Subdivision Comments

Date: 09/10/21

RE: LP-21-00002 Suncadia Phase 3 Division 17 Tumble Creek

SUNCADIA RESORT LLC
PHASE 3 DIVISION 17
 CONCEPTUAL UTILITY PLAN
 WASHINGTON
 KITITAS COUNTY

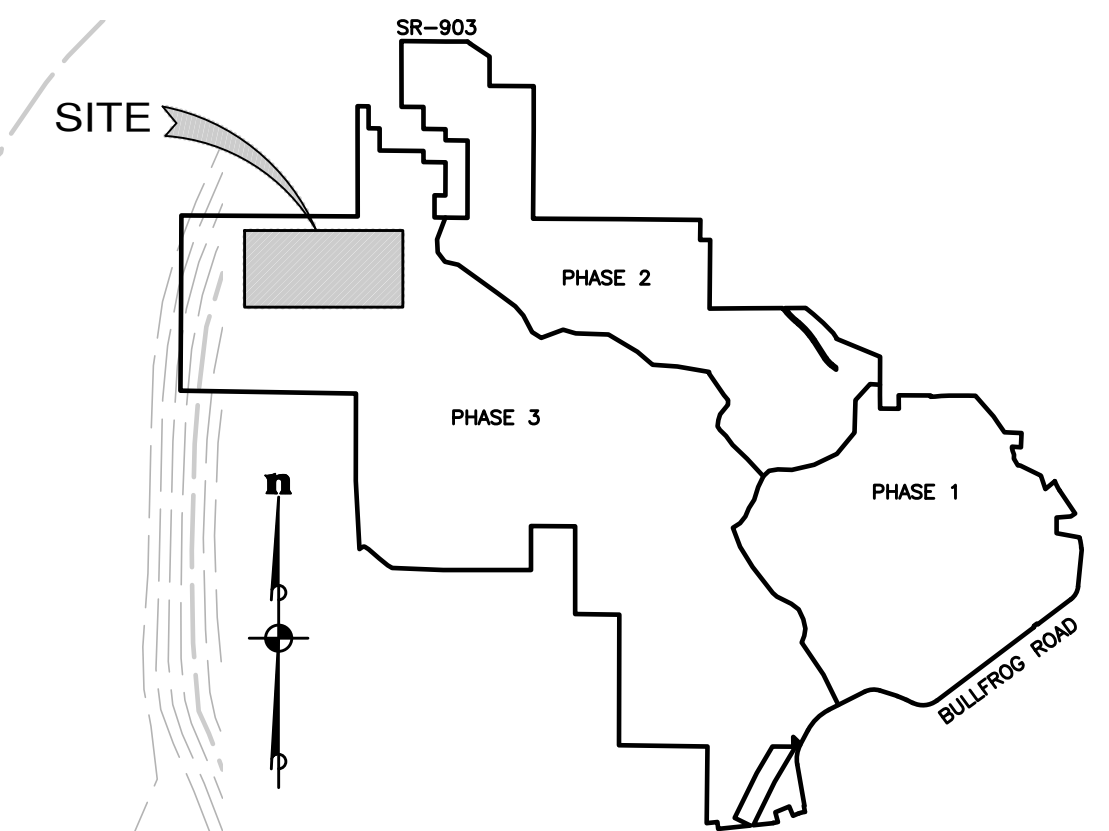
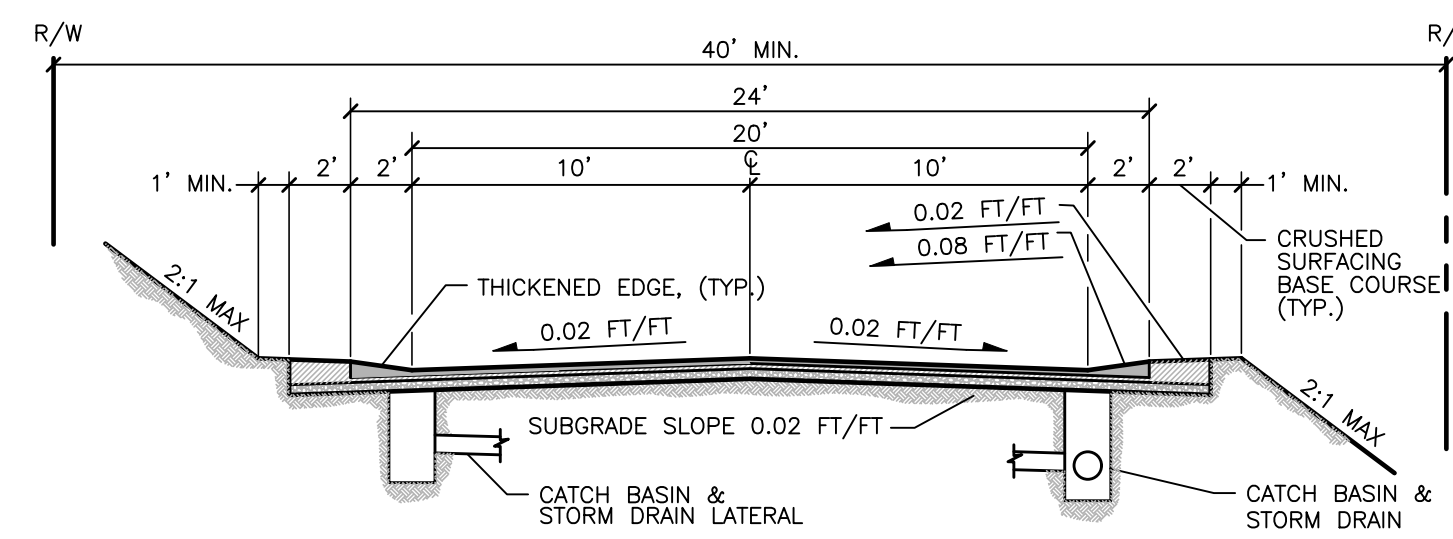
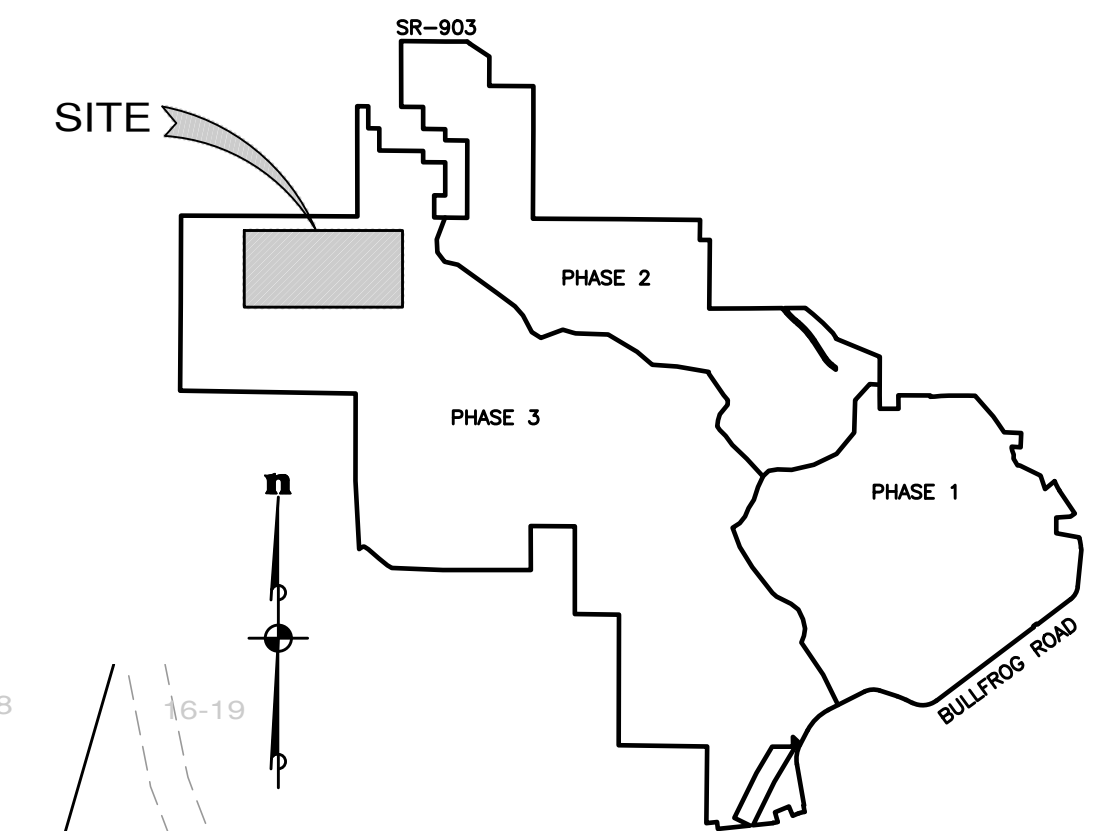
The collected raw wastewater from the development will be conveyed by means of onsite gravity sewer to the existing gravity sewer in Tumble Creek Drive.

Please clarify how the raw wastewater will be conveyed from gravity septic to an existing system in Tumble Creek. Is this system an on-site system? Or is this a connection to the lift station running to a wastewater treatment facility?
